Cherokee Metropolitan District, Additional Office on Frank Road, PPR-17-061

Please accept the following comments from El Paso County Public Health regarding the project referenced above:

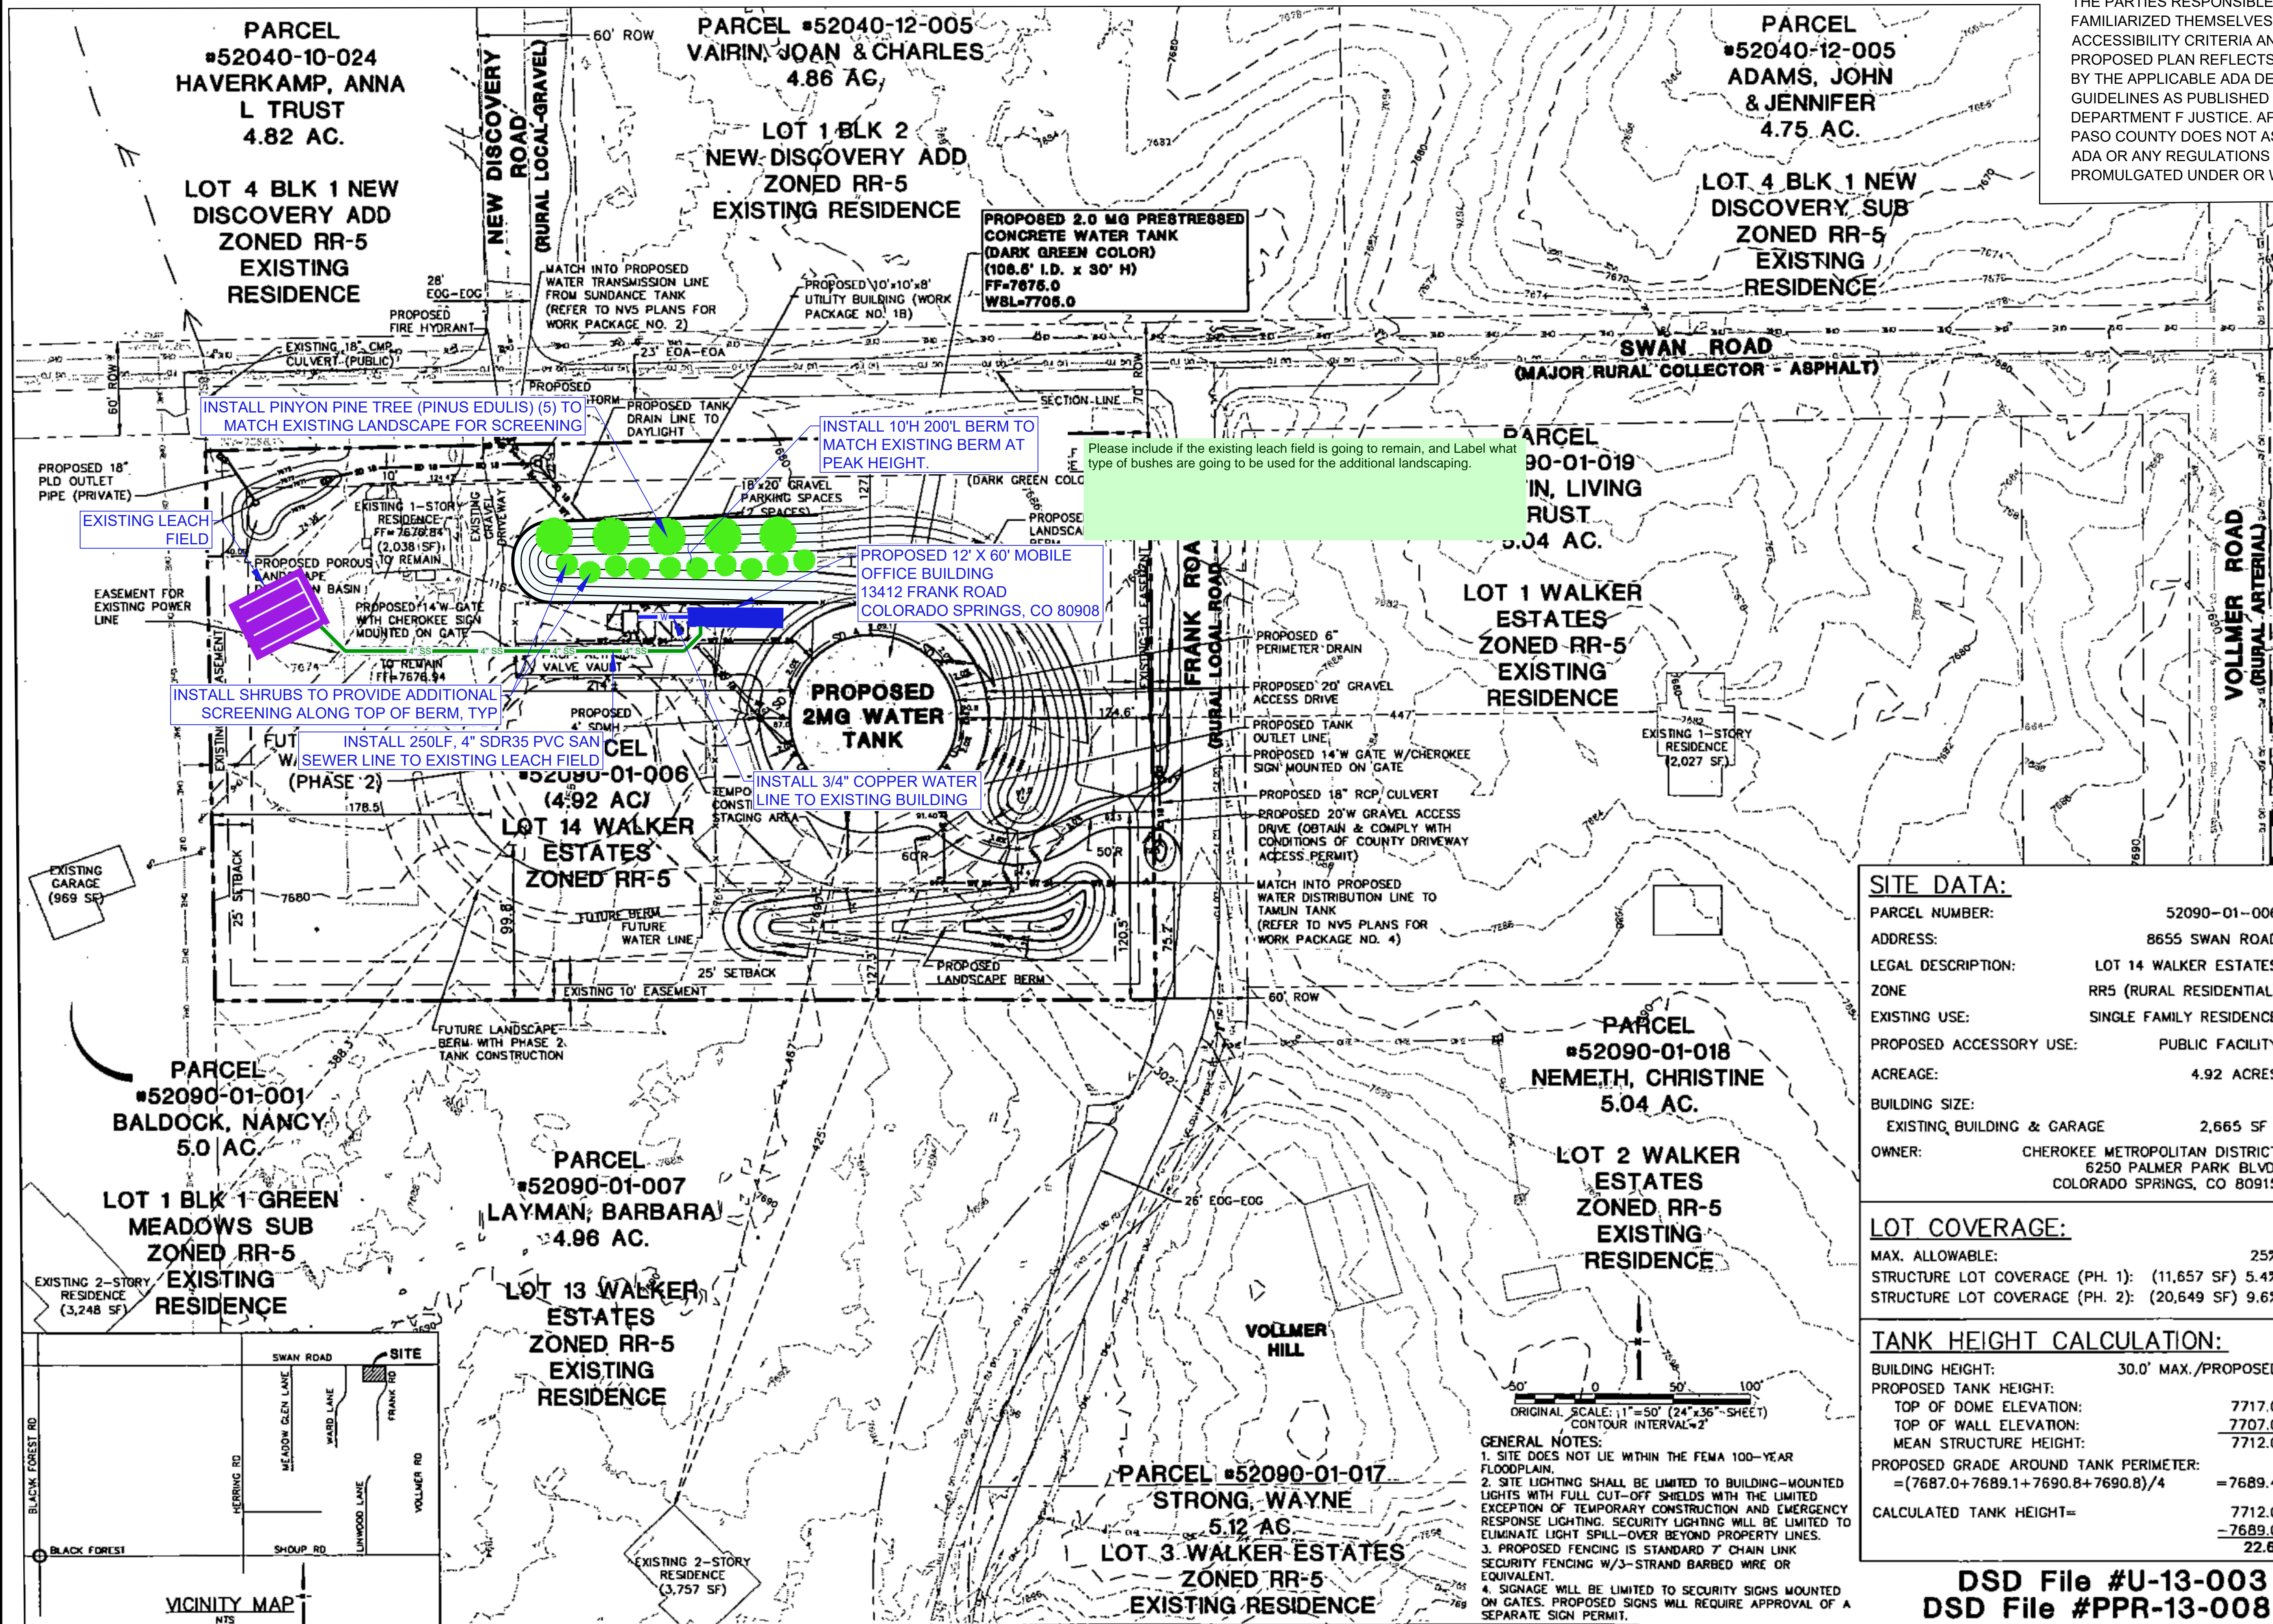
- The proposed additional office space does not include a restroom; however, this plan shows the office connected to an existing soil treatment area approved in 1987 for a 2-bedroom house located west of the proposed office. A review of the capacity of the existing onsite wastewater treatment system (OWTS) by a Colorado Registered Professional Engineer of the size of the soil treatment area and septic tank for the proposed wastewater flow associated with the office employees is required to be submitted to EPCPH for review. A Minor Repair Permit from El Paso County Public Health is required if connection to the OWTS is found to be feasible by the engineer.
- No other El Paso County Public Health issues noted with the approval of this request.
